Subject: Planning Consultation on: AL/107/21/PL

Response to Planning Application

Application ref: AL/107/21/PL

Location: Woodgate Centre Oak Tree Lane Woodgate PO20 3GU

Scale: 1:500 @A0	Drawn I Checked DP MP	Date: 19/08/2022
Job Number: LAS 103	Drawing Number: 05	Revision: H

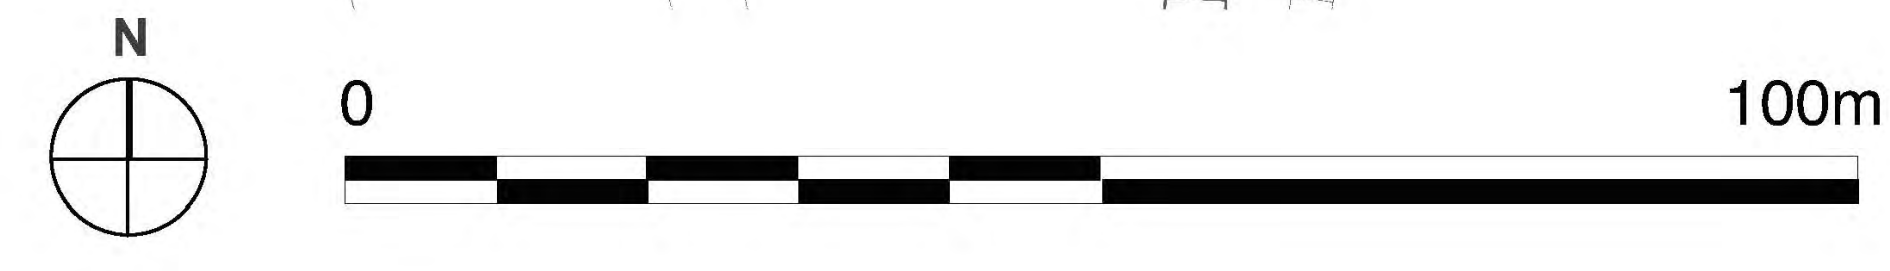
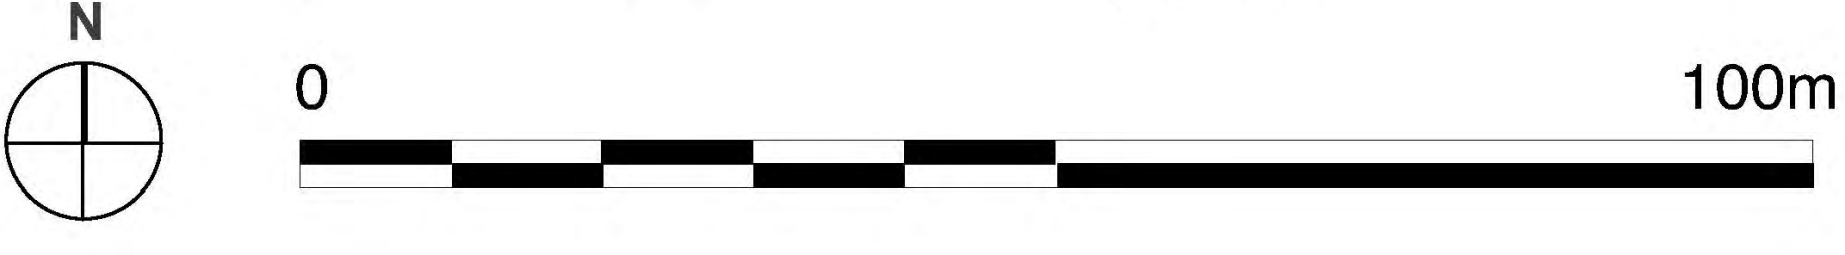
- Hard and Soft landscape Proposals Plan No E-W Link and Associated implementation and Planting specification – which appear suitable
- Hard and Soft landscape Proposals Plans Sheets 1, 2, and 3 (ref LAS-103-05E) and Associated implementation and Planting specification parts 1, 2 and 3 of 3 – which appear suitable

Further detail regarding on plot landscaping will need to be submitted for approval or conditioned for further submission.

~~An indicative landscape scheme has been shown in dwgs Hard and Soft Landscape Proposals Plan Sheets 1 & 2 of 2 05 Rev D, which will need to be elaborated on with plot specific detail shown in plan form.~~
